I wish to make a comment the above planning application.

AGC Consultants 14 Seafeld Ave. Mistley Essex CO11 1UE 07792 830411	
Client	Miss Victoria Baker
Project title	Alterations at: The Swedish House Swedish Estate, Wix CO11 2RS
Drawing title	Proposed floor plans
Scale	1:50@A2
Date	25/11/21
Dwg No	0348/PL/03
Rev No

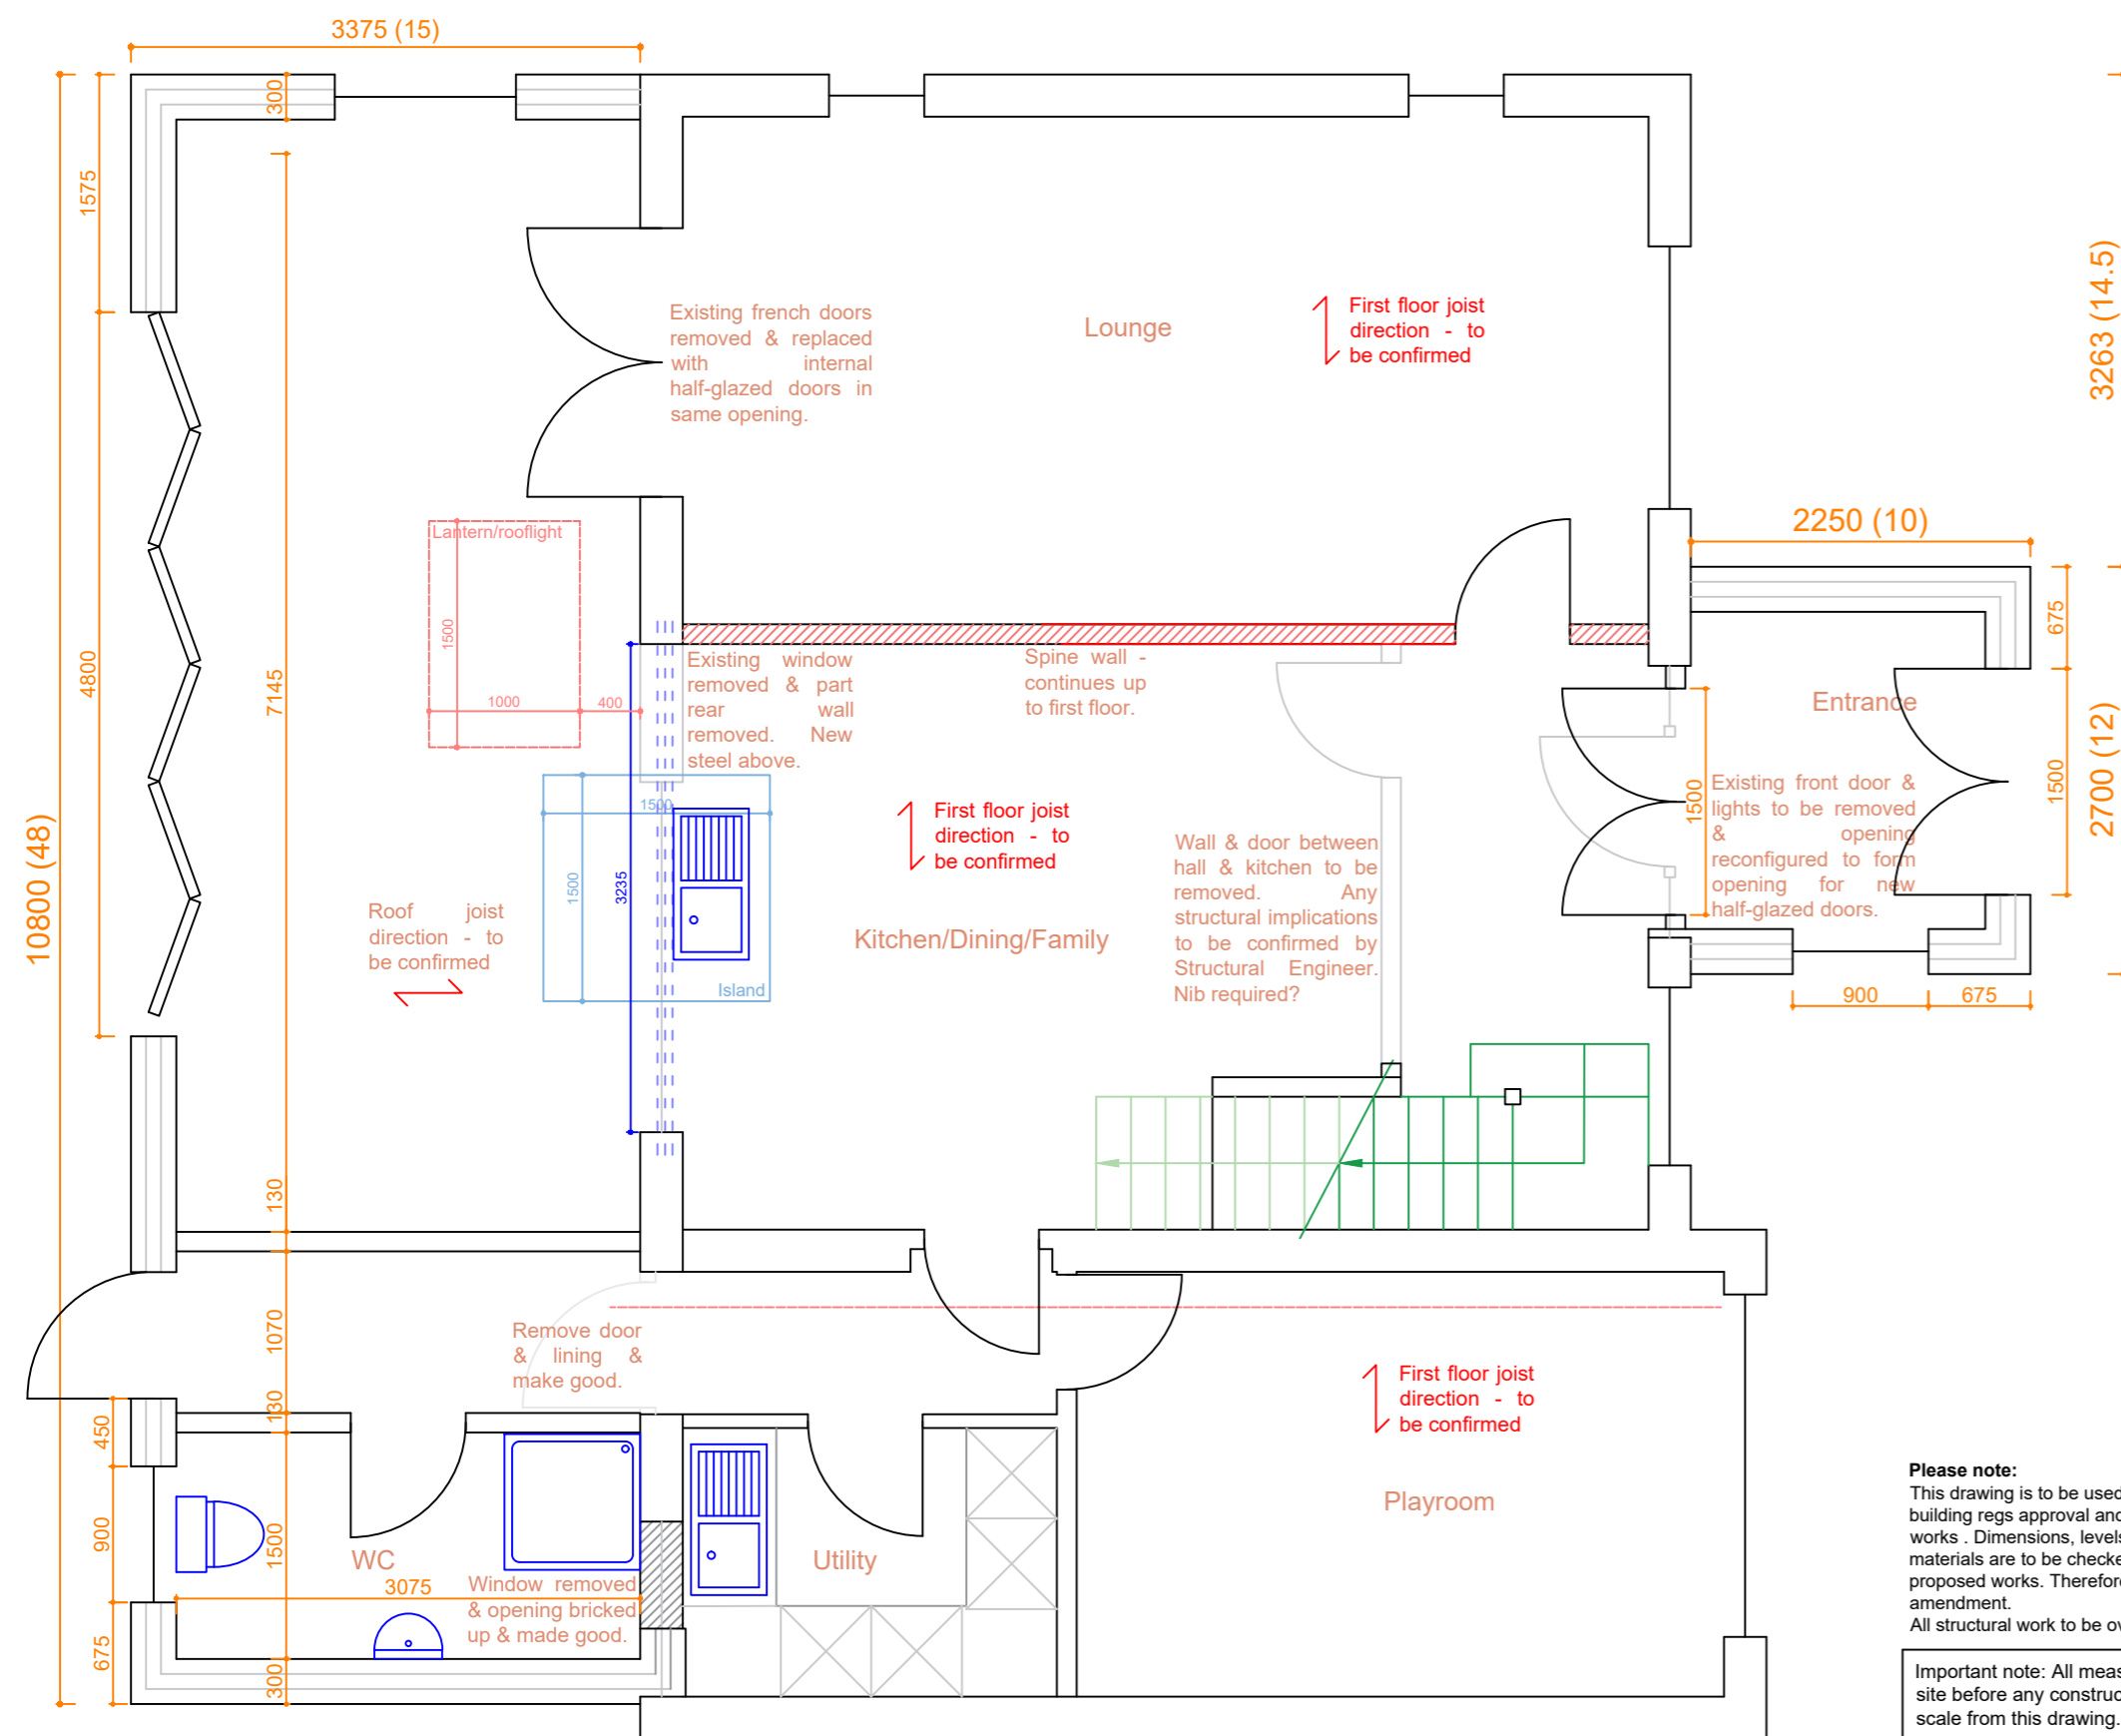
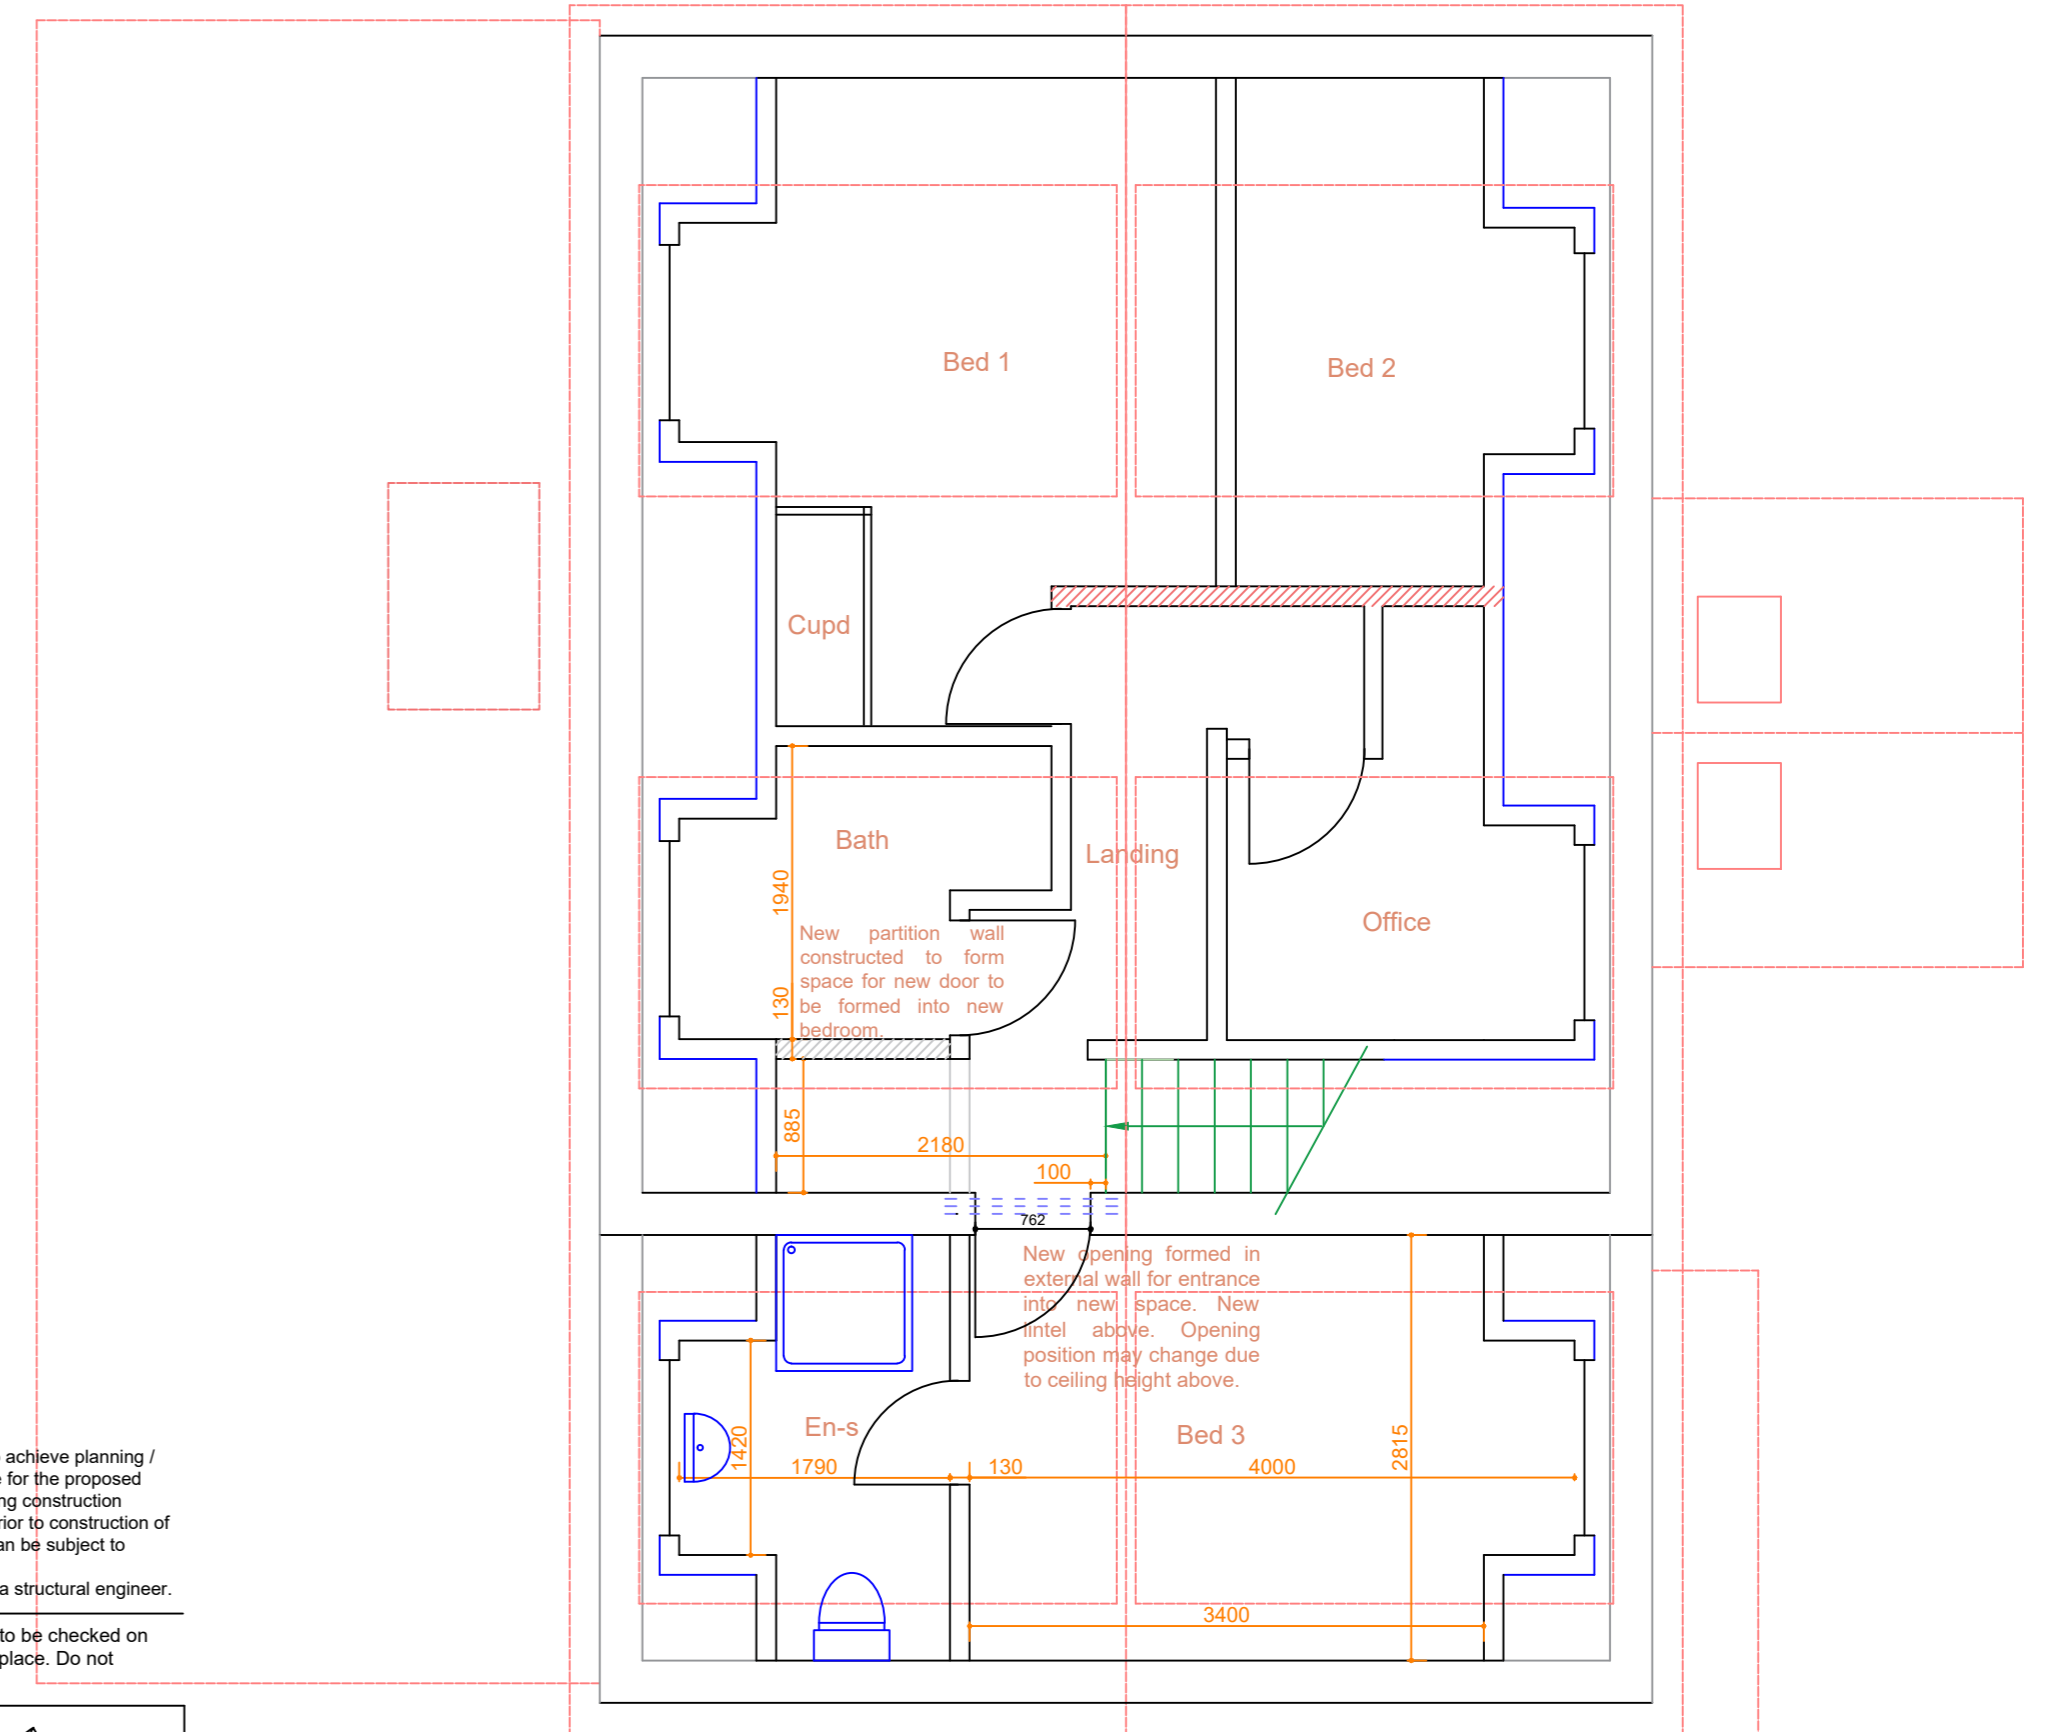
I am concerned about the new build extension to the rear of the current building. The end wall of this extension effectively runs along the boundary of my property for 3.375metres and is 3 metres high and my closest ground floor window will be 2 metres from this wall. Also the extension is to the South of my property and especially in the winter most of the light comes from this window hence I am concerned that the light through my window will be significantly reduced by the new construction.

I have no objection to the principle of an extension being built onto the rear current building but would prefer that the design is modified so that the light entering my property is not reduced.
